**SSD 6010 - One Residential Building (Student Accommodation) within
Darling Drive Plot**

Submission by:

Christophorus Susanto

26 July 2013

SHADOW DIAGRAMS: PLAN SHOWING THE HAYMARKET, WINTER SOLSTICE

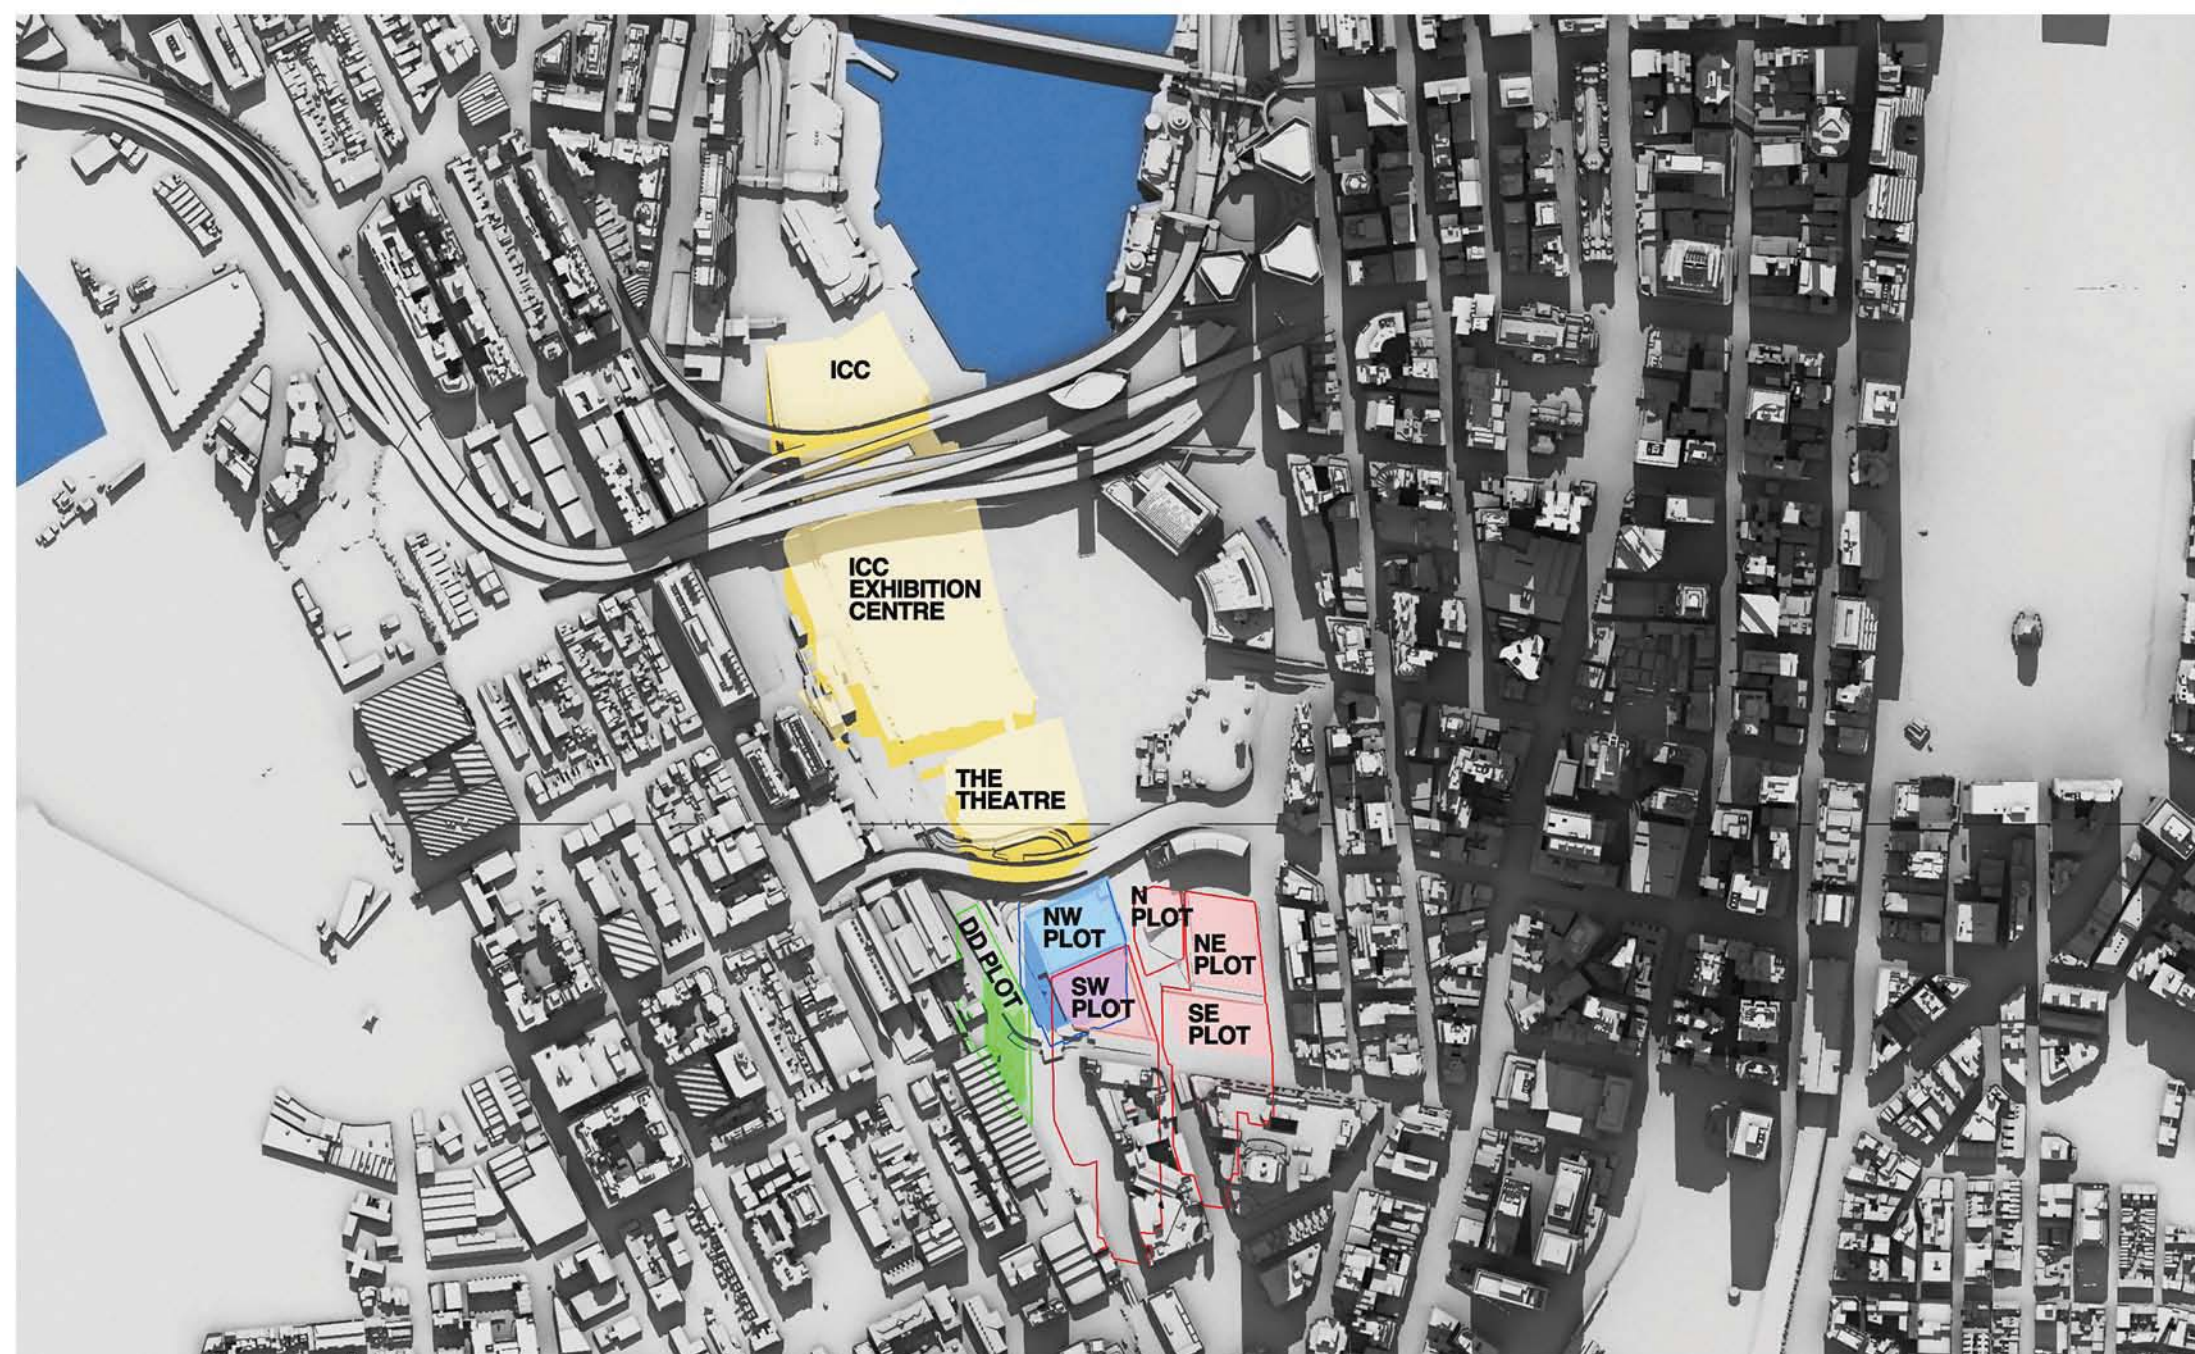
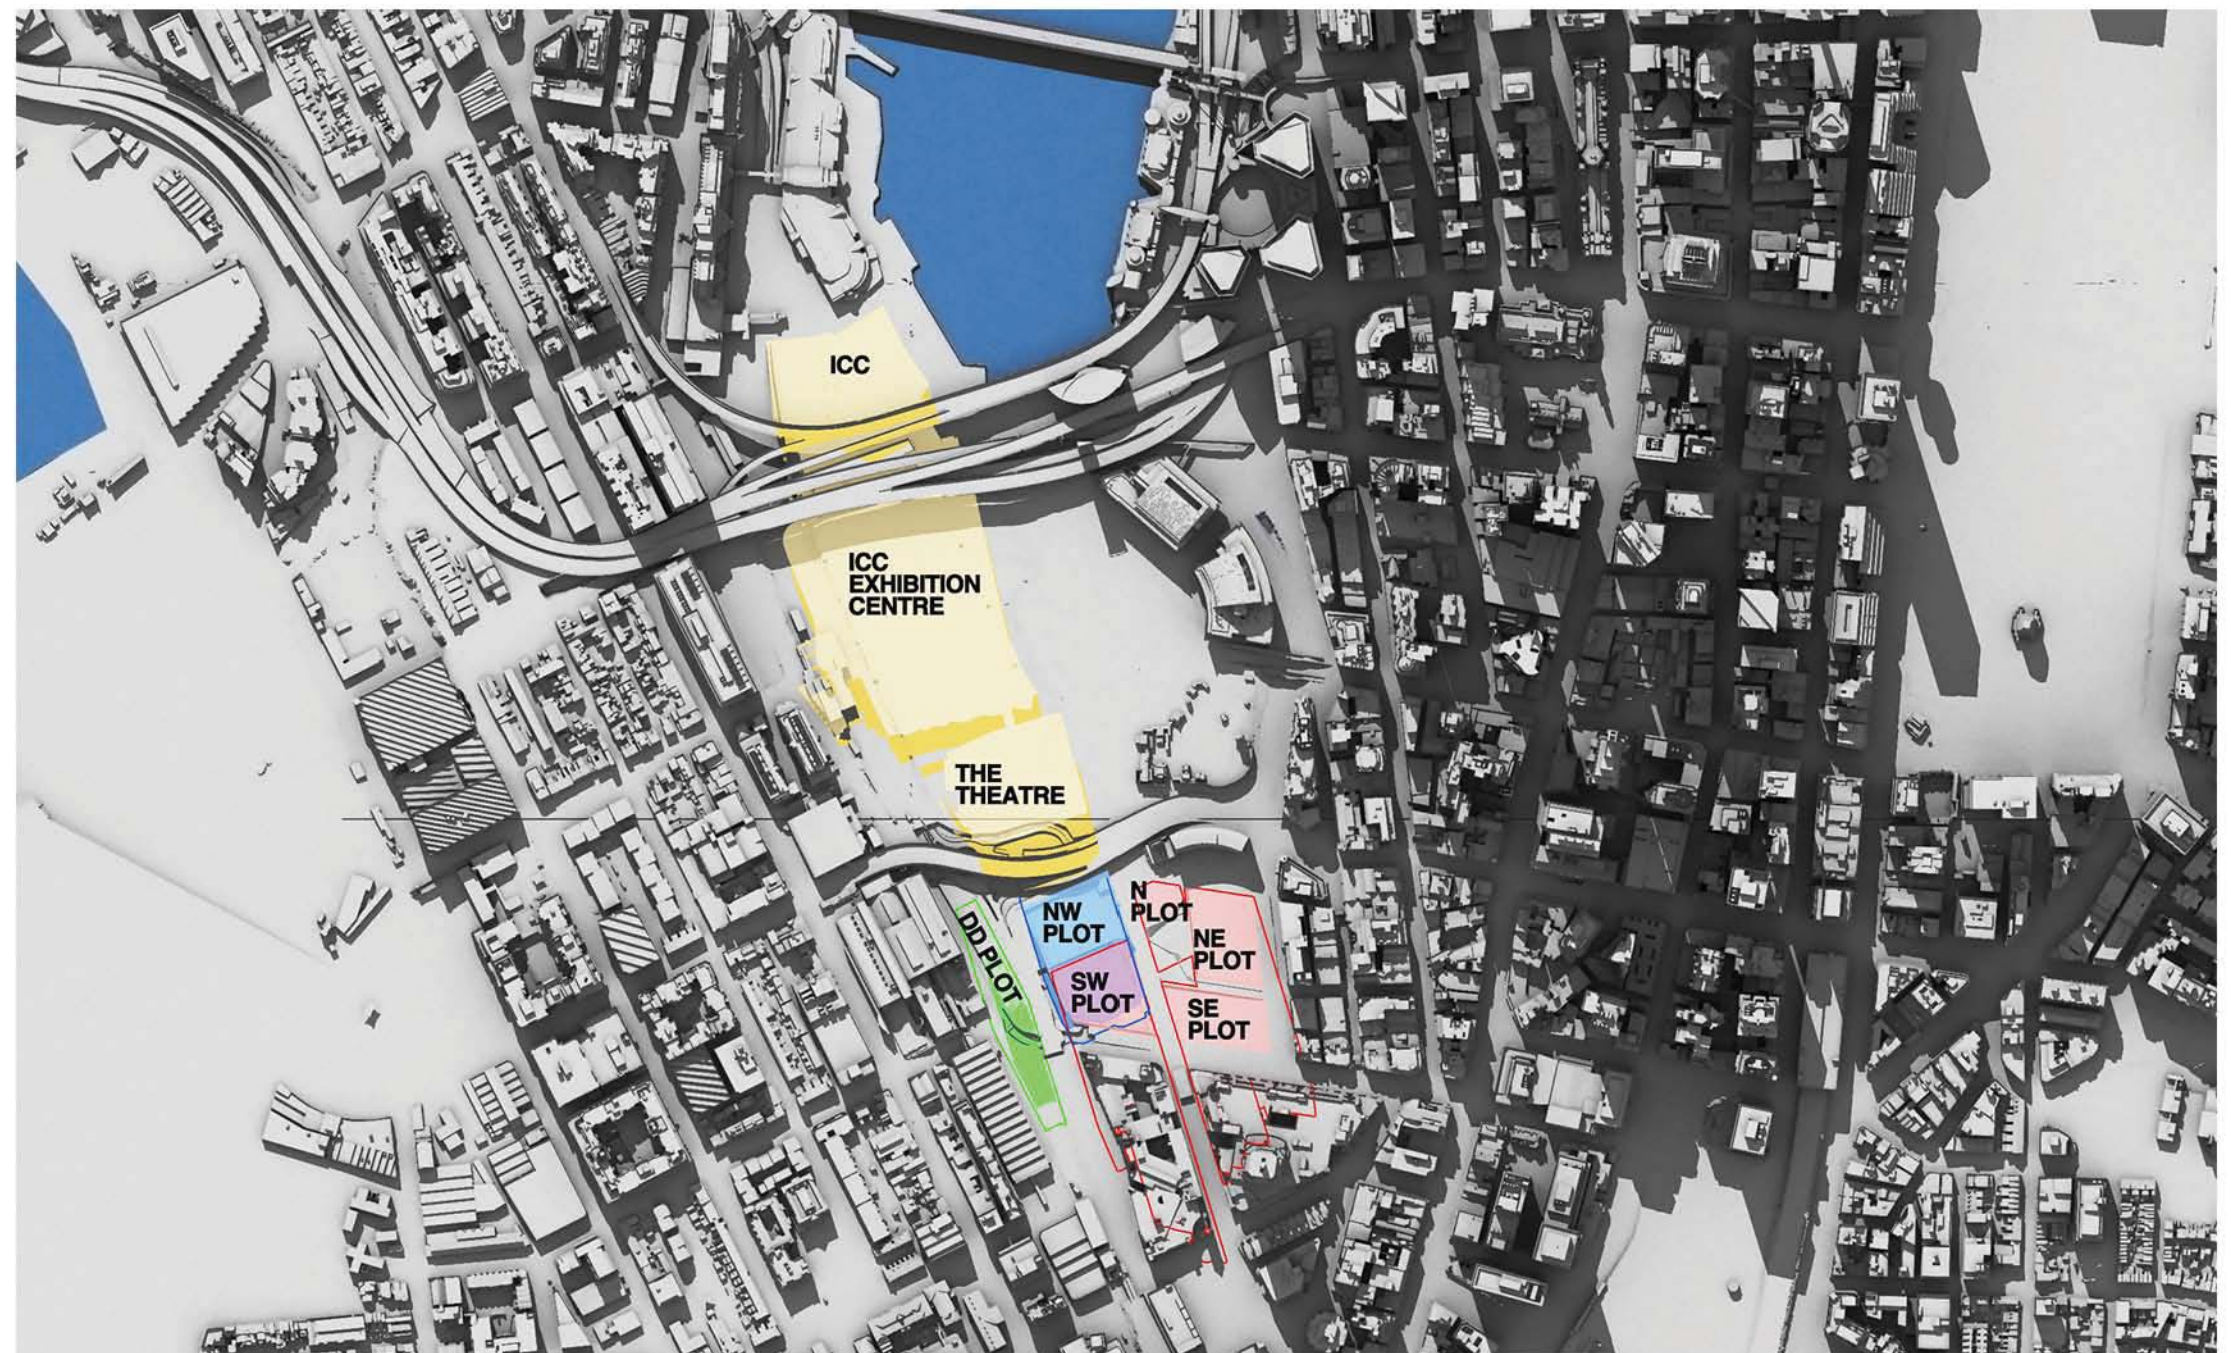
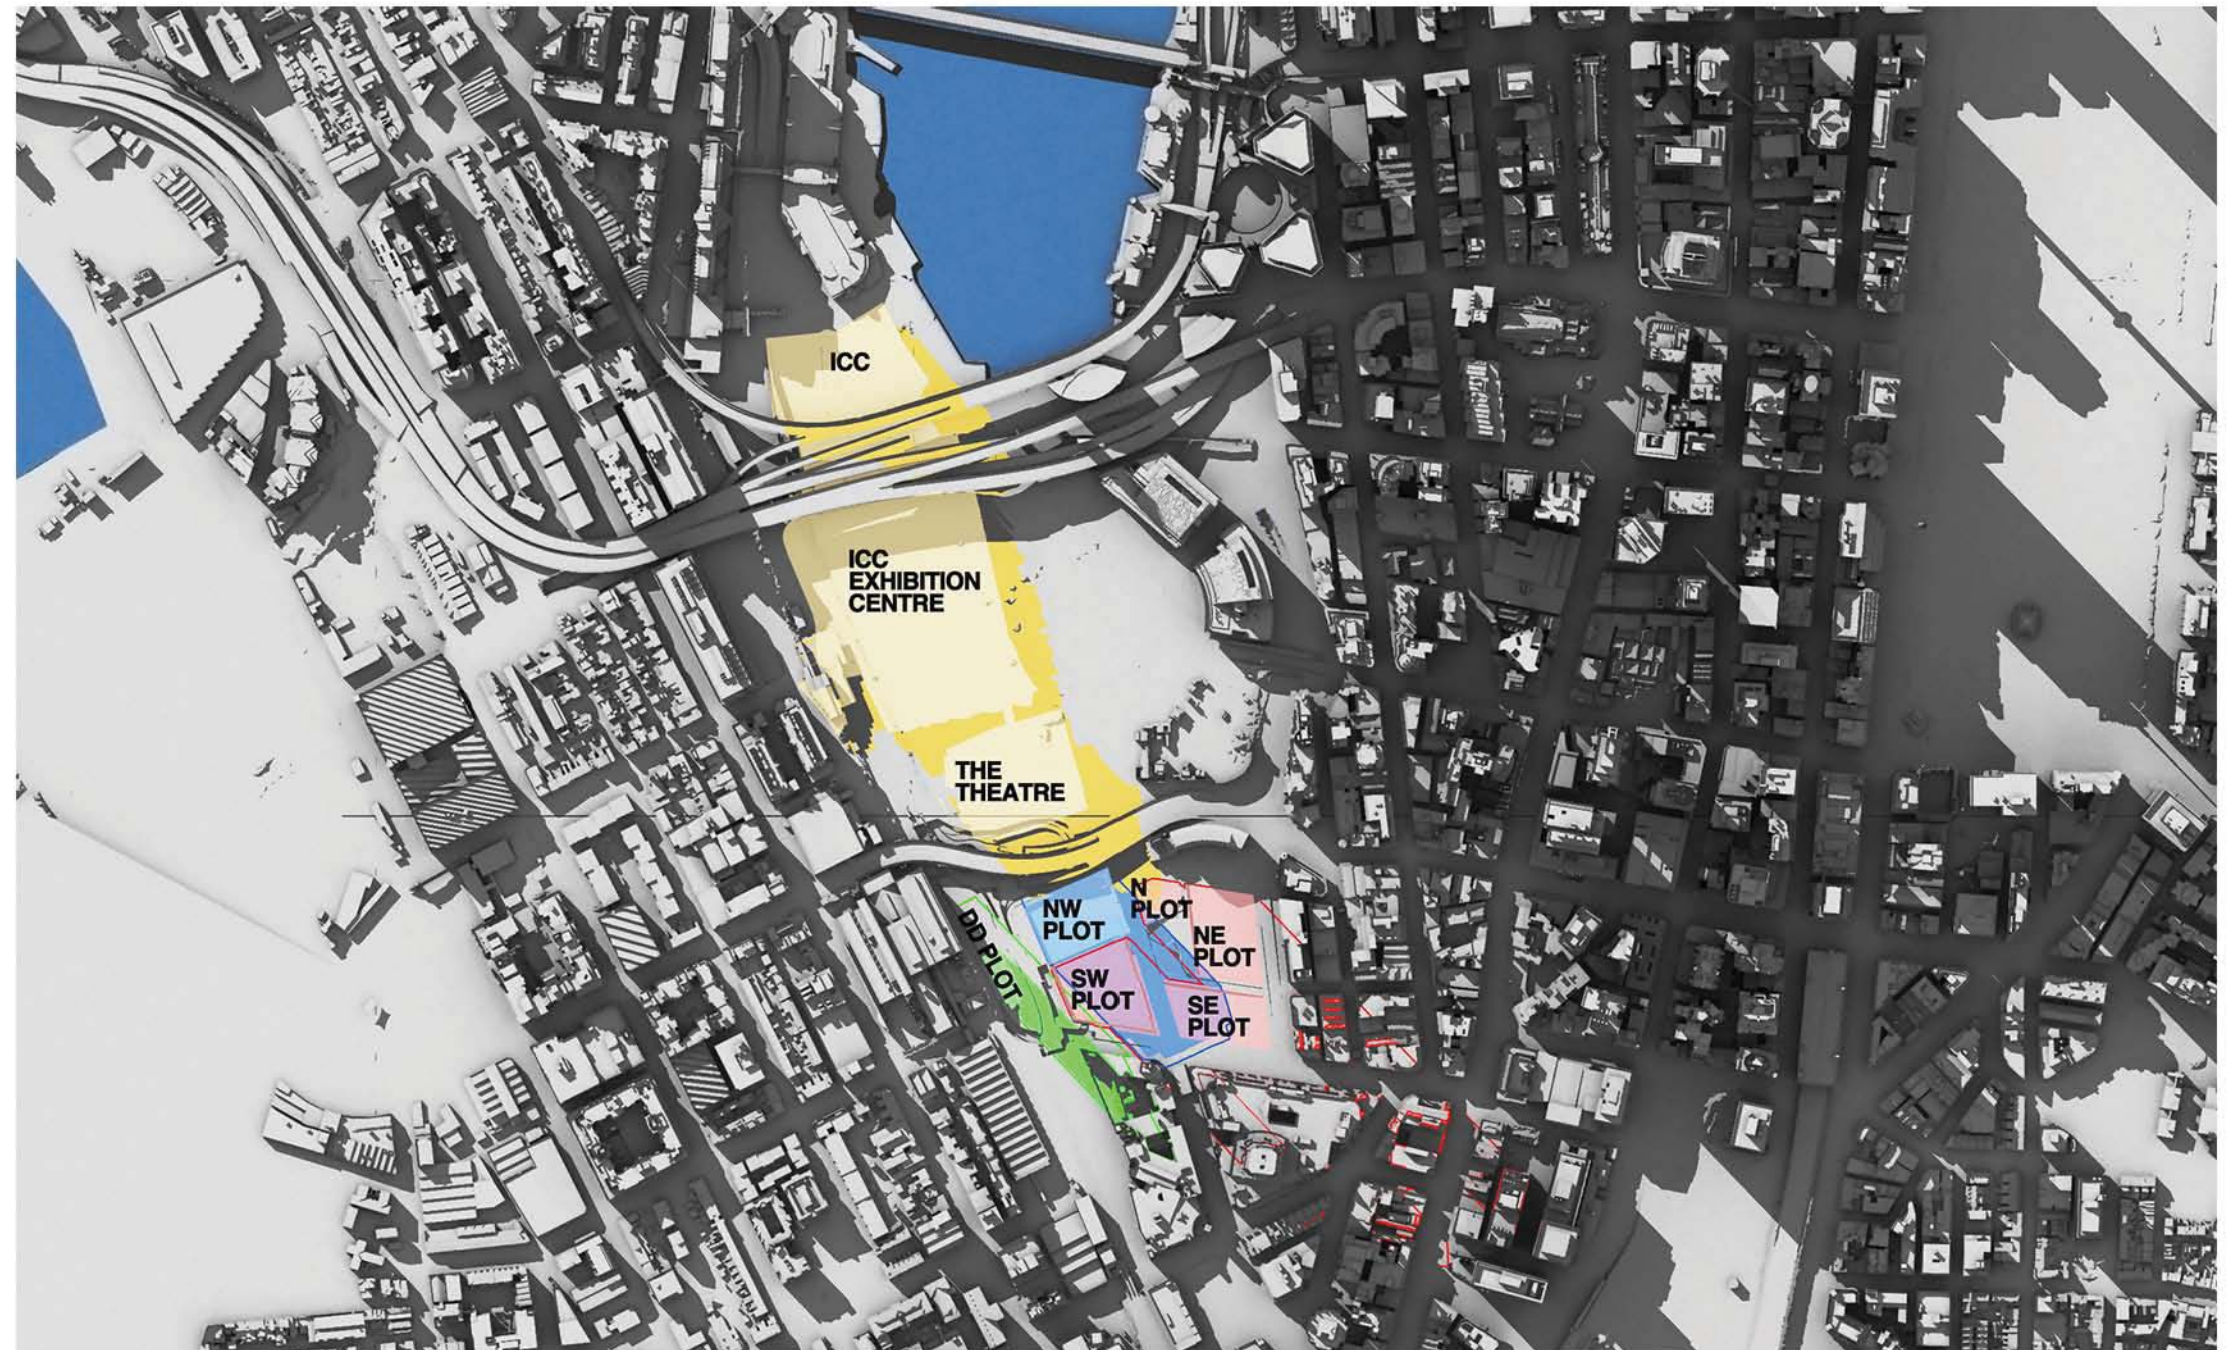
The proponent provides diagrams but fails to discuss the existing shadowing of the west façade of The Peak.

At 9am, 10am and 11am the west façade is totally in shadow due to other parts of The Peak building itself.

At 12pm there is still substantial existing shadowing on the west façade caused by the irregular shape of the west facade.

At 1pm the existing shadowing has been substantially removed, but not totally removed.

It can be concluded that some single aspect apartments on the west façade and some south-west dual aspect corner apartments currently receive less than 2 hours direct sunlight to habitable rooms and 50% of the private open space between 9am and 3pm on 21 June.

By 2pm the existing shadowing has been totally removed, but that is too late to achieve two hours of direct sunlight before 3pm.

At 9am, 10am and 11am the west façade is totally in shadow due to other parts of The Peak building itself.

At 12pm there is still substantial existing shadowing on the west façade caused by the irregular shape of the west facade.

At 1pm the existing shadowing has been substantially, although not entirely, removed. However, overshadowing of lower levels of the west façade by the concept proposal parameter plan shadows for the N,NE and SE plots has already started.

By 2pm the existing shadowing has been totally removed. However, overshadowing of the west façade by the SSDA4 and SSDA5 buildings has appeared and risen further up the west façade than the concept proposal parameter plan shadows for the N,NE and SE plots, which is still present.

At 3pm, the proponent states correctly that 45-45% of the western façade is overshadowed by the SSDA4 and SSDA5 buildings.

It can be concluded that, as a result of combination of the proposed development with existing shadowing of the west façade, some single aspect apartments on the west façade and the south-west dual aspect corner apartments which currently receive less than 2 hours direct sunlight to habitable rooms and 50% of the private open space between 9am and 3pm on 21 June will suffer additional overshadowing. It is beyond our skills to count the number of such apartments. We note that the proponent has made no attempt to do so.

Rather than counting the number of units which will not meet the DCP guidelines, the proponent attempts to trade-off direct sunlight at 4pm for lack of direct sunlight during the period 9am to 3pm. There is no provision in the DCP guidelines for such a trade-off.
